Rezoning Transportation Analysis
Petition Number: Insert Zoning Petition #2021-219
General Location Identifier: 12521103

From: Brandon Brezeale, PE
Brandon.Brezeale@charlottenc.gov
704-432-5561

Reviewer: Walta Blackmon, PE
Walta.Brumskine@charlottenc.gov
704-432-1556

Date	Description
01/21/2022	First Review (WB)
02/21/2022	Second Review (WB)
03/15/2022	Third Review (WB)

RZ-1.0

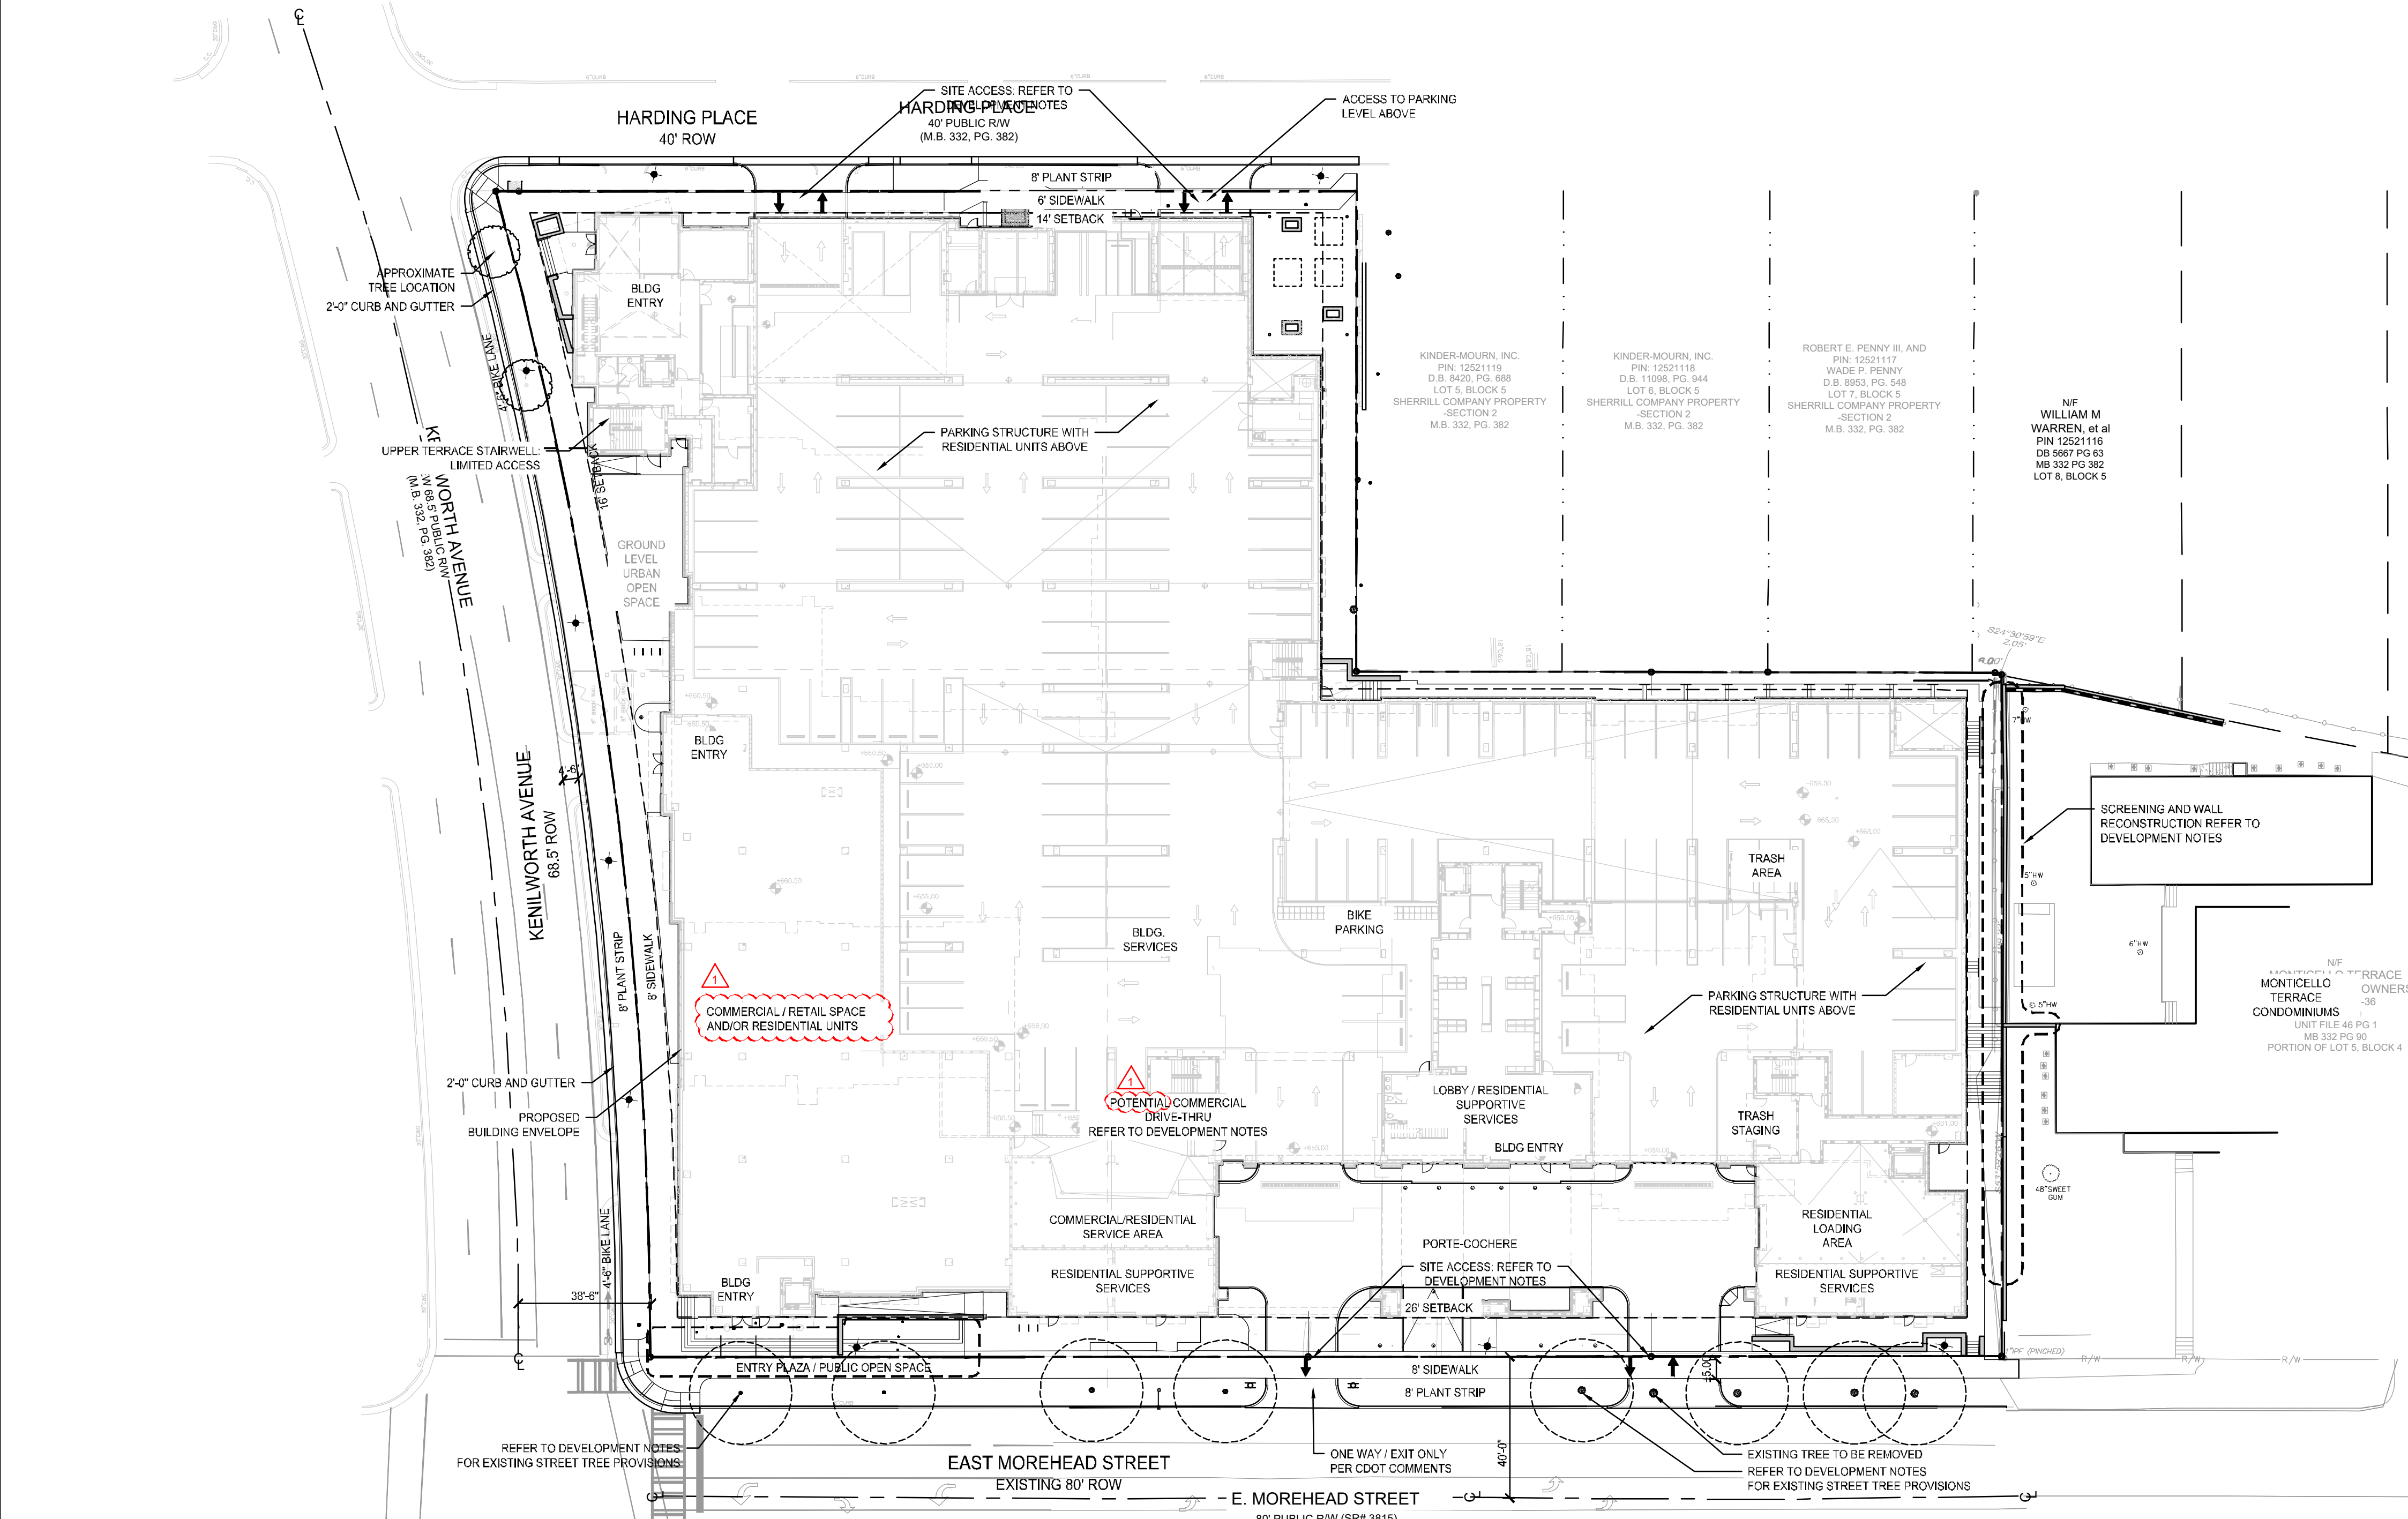
1. ~~**Curblin**~~: The proposed zoning district has a setback measured from back of the existing or proposed future curblin.

- a. ~~**Morehead Street**~~: The future location of curb and gutter measures at 36-feet from the centerline to the back of curb to accommodate buffered bike lanes; however, no curb relocation is being required with this petition and the existing curb and gutter may remain at its current location.
 - b. ~~**Kenilworth Avenue**~~: The existing curb and gutter is in its future location.
 - c. ~~**Harding Place**~~: The existing curb and gutter is in its future location.

~~Label and dimension the curb and gutter from the centerline for each road on the site plan.~~
